Reference No:	2023/62/93679/W
Site Address:	Hey End Cottage, 17, Cliff Lane, Holmfirth, HD9 1XE
Description:	Demolition of existing extension and erection of single-storey extension, alterations to patio and steps (within a Conservation Area)
Recommending Officer:	Molly Storer

DECISION – CONDITIONAL FULL PERMISSION

Officer Report

EAST ELEVATION / SECTION THROUGH STEPS

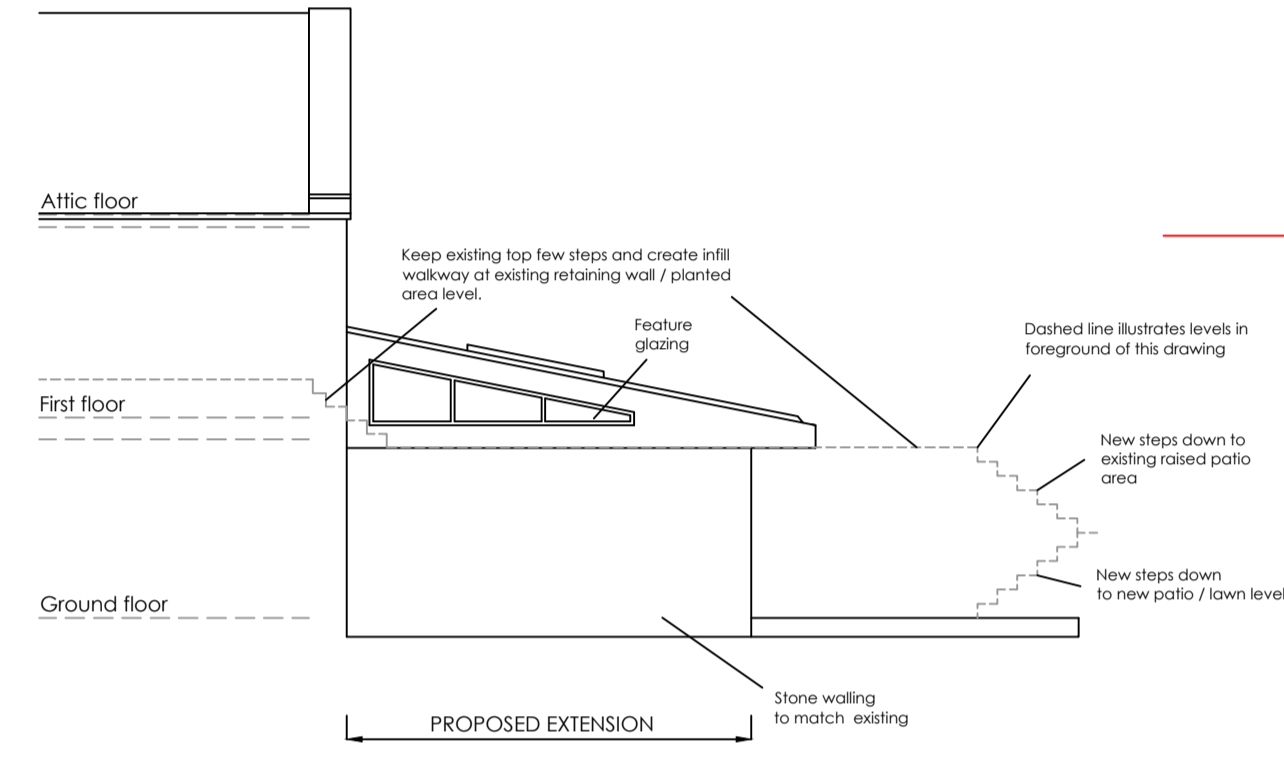
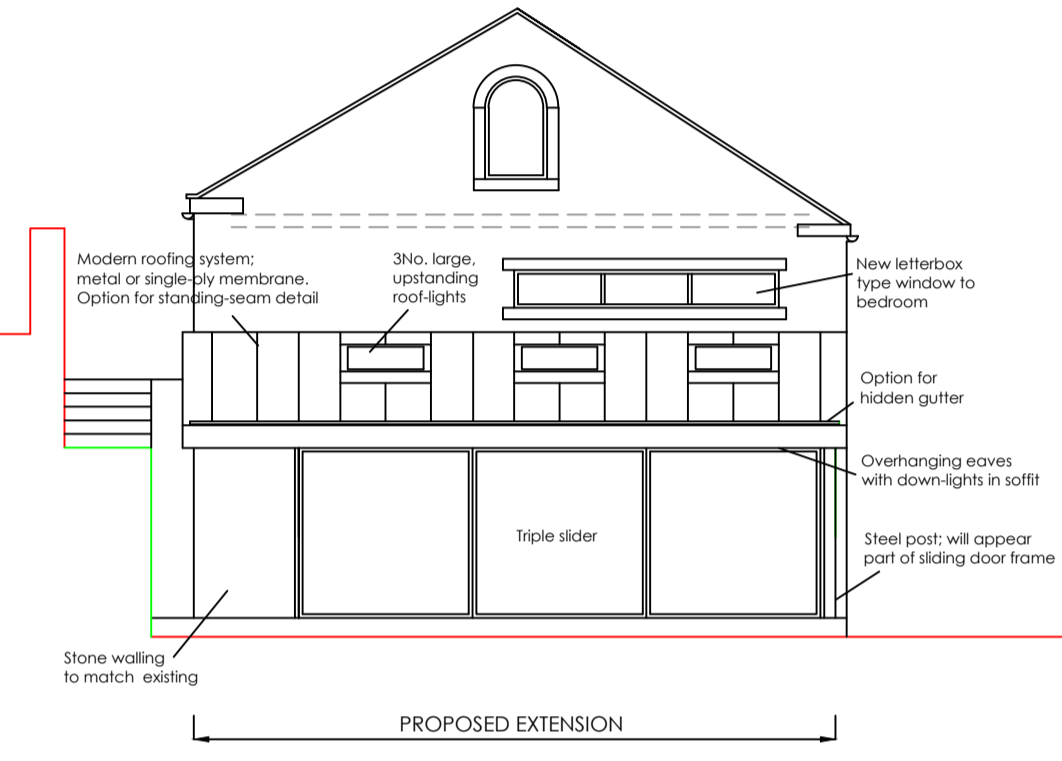
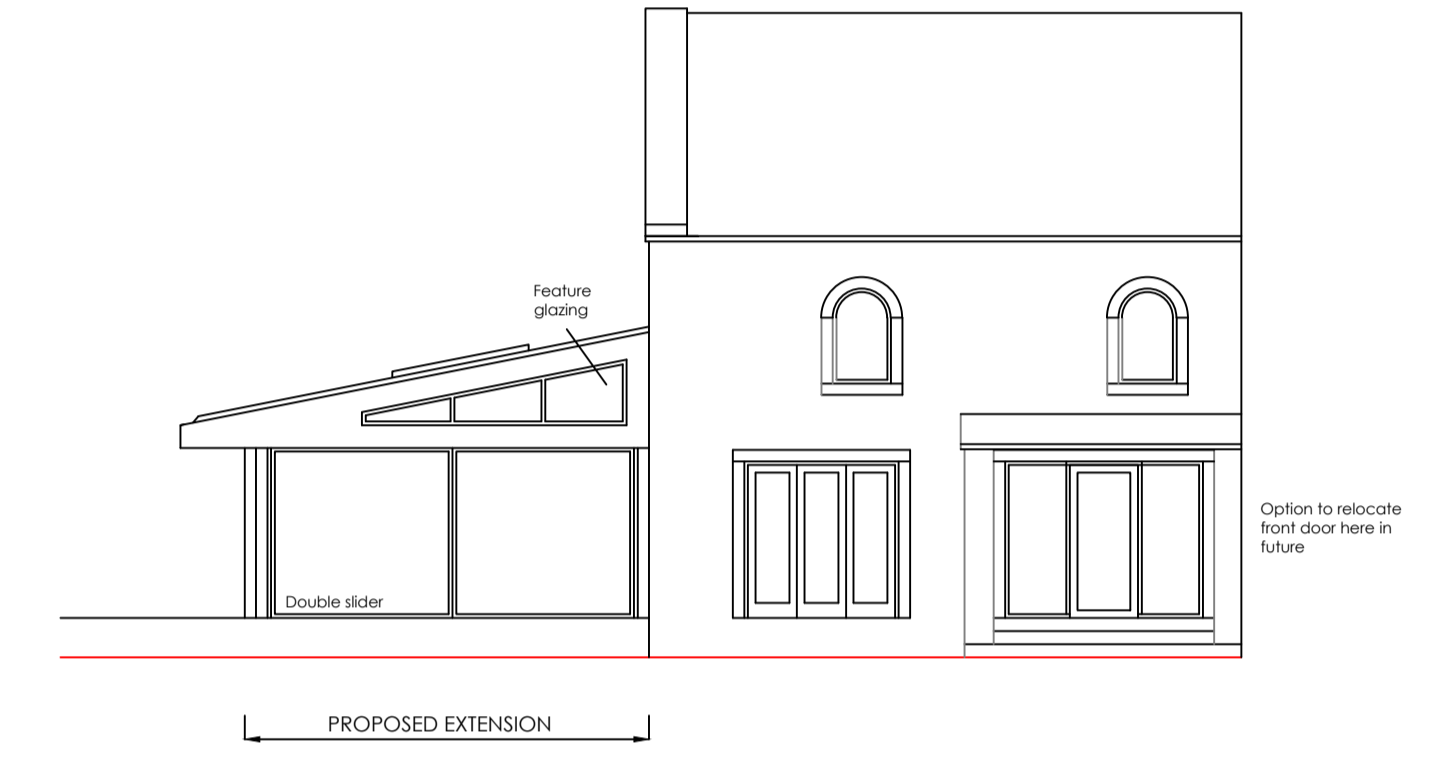
The original plans showed that the existing small gable extension would be demolished and replaced with a much larger shallow mono-pitch zinc roofed extension. However, the Conservation and Design Team raised concerns about the proposed development on heritage and design grounds particularly with regards to statutory duties under sections 66(1) and 72(1) of the Planning (Listed Buildings and Conservation Areas) Act 1990, policies LP24 and LP35 of the Local Plan and paragraphs 206 and 208 of the NPPF (20 December 2023). The agent was of the LPA's concerns in relation to the affected heritage assets, in this case the attached Grade II listed cottages at 13-15 Cliff Lane and the Holmfirth Conservation Area in which the property is situated.

It was suggested that a stone slate pitched roof in the same orientation as the main building would be more in style and in keeping with its character. In addition, it was recommend that a number of amendments be considered to make the development subservient to the host property and in order to further preserve the character of the conservation area it was recommended that less glazing should be utilised and conservation roof lights be incorporated to make the extension more traditional. It was further advised this would also reduce the impact of the proposal upon the setting of the listed cottages and would preserve the character of the conservation area.

The proposal would see the construction of a wall and infilling between the new wall and existing retaining wall, this would also incorporate a new

external stairway to allow access to remain. It is recommended a condition is included which requires the external walls and steps to be constructed from natural stone. On the basis of the inclusion of the recommended condition this element of the scheme is considered to have an acceptable visual impact and would not significantly alter the appearance of the host property or affect the setting of the Conservation Area.

The agent responded with amended plans which showed an adjusted plan based on the suggestion from conservation officers. These plans will be assessed in the following report.

In this instance the extension will be located to the side away from the listed buildings and will have a stone slate pitched roof in the same orientation as the main house to ensure that the design harmonises with the original dwelling and is in keeping with the local area. This also aligns with character management principles of Holme Valley Landscape Character Area 4 which states that regard should be had to the key characteristics that give these areas their distinctive character and should respect, retain, and enhance the character of existing settlements, including vernacular building styles, settlement patterns, alignment of the building line and the street scene.

5. The rooflights hereby approved shall be Conservation style or similar and fitted flush to the roof plane. Glazing shall have a thickness of no more than 16mm at 4:8:4 ratio. The rooflights approved by this condition shall be retained thereafter.
